WESTERGATE STREET AND MEADOW WAY, WESTERGATE, WEST SUSSEX

Stage Road Safety Audit - Designers Response

- 1.1.2. This report provides a Designer's Response to the Stage 1 Road Safety Audit (RSA) completed by Acorns Projects Limited for the proposed site accessed arrangements, which consist of a four-arm traffic signal junction at the A29 / Meadow Way / Pine Close. This RSA is aligned with Design Manual for Roads and Bridges GG119 guidance. An RSA brief, which was shared with Acorns Projects Limited prior to completion of the audit, is included in Appendix A.

- 1.1.3. The RSA report is included in Appendix A of this document and was based on drawing 3258/GA/003.
- 1.1.4. Section 2 of this report sets out the issues raised by the RSA and WSP's response as Design Organisation.

SCALE @ A1: 1:250	CHECKED: LRB	APPROVED: LRB
CAD FILE: LAW-WSP-ZZ-ZZ-TP-00001.DWG	DESIGN-DRAWN: MFB	DATE: December 2022
PROJECT No: 70013258	DRAWING No: LAW-WSP-ZZ-ZZ-TP-DR-00001	REV: G

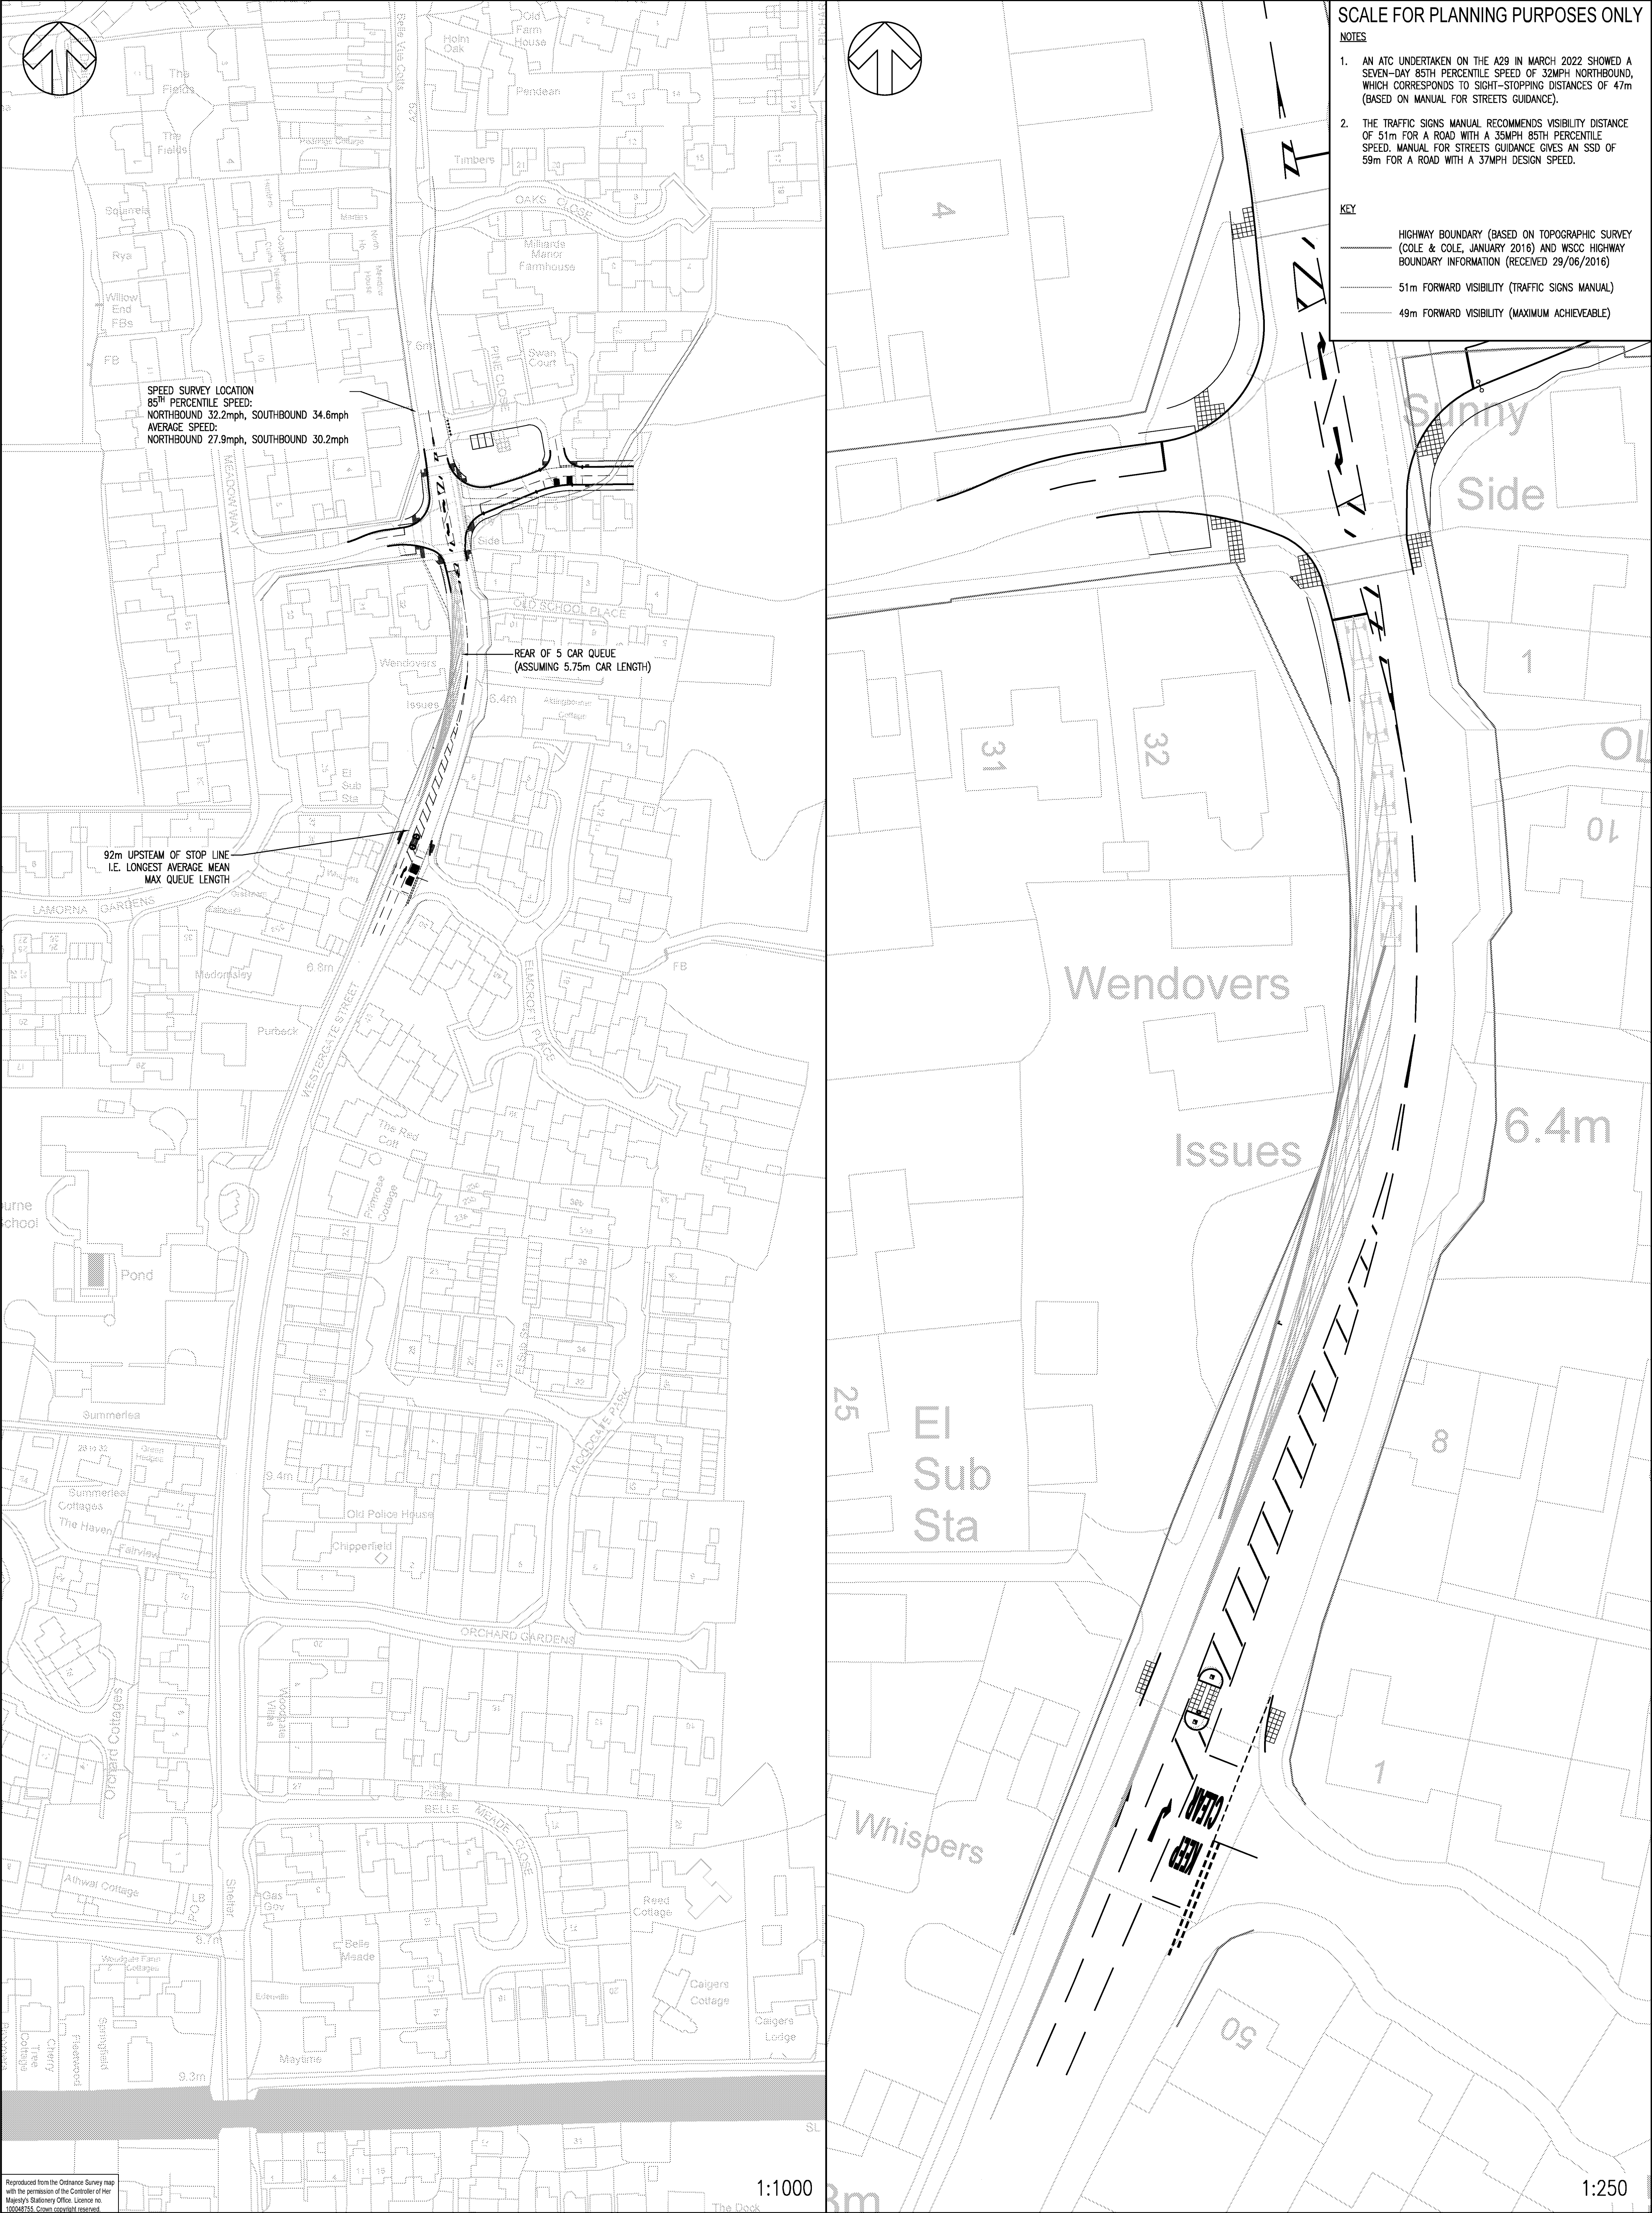
- 2.2.1. Locations 1 & 2 - On the south eastern and north western corners of the proposed traffic signal junction (Drawing No. 3258/GA/004 Rev F).

- 2.2.2. An identified Departure from Design Standard with regard to junction intervisibility could lead to a potential increased risk of side impact vehicular collisions occurring or nose to tail shunt type collisions occurring, whereby vehicle occupants could sustain personal injury.

- 2.2.3. The Design Organisation offer the following mitigation measures to reduce and minimise the negative impact of the identified Departure from Design Standard with regard to junction intervisibility, as described within the December 2022 WSP Stage 1 Road Safety Audit Brief document:
- ※ “Yellow box junction marking provided to assist with precautionary approach by west bound vehicles”;
 - ※ “All red extending detector loops to be considered during detailed design to ensure junction is clear before allowing movements with poor intervisibility”;
 - ※ “MOVA detection will facilitate precise stage change operation thereby reducing possibility of vehicles running amber lights and conflicting with pedestrian movements”.

- 2.2.4. Problem accepted, noting that a ‘Keep Clear’ box markings have been included on the westbound approach. This is shown on the updated Site Access General Arrangement Drawing LAW-WSP-ZZ-ZZ-C-DR-0006.
- 2.2.5. Recommendations related to the provision of an all-red detector and use of MOVA detection are also accepted and will form part of the detailed design process for the junction.
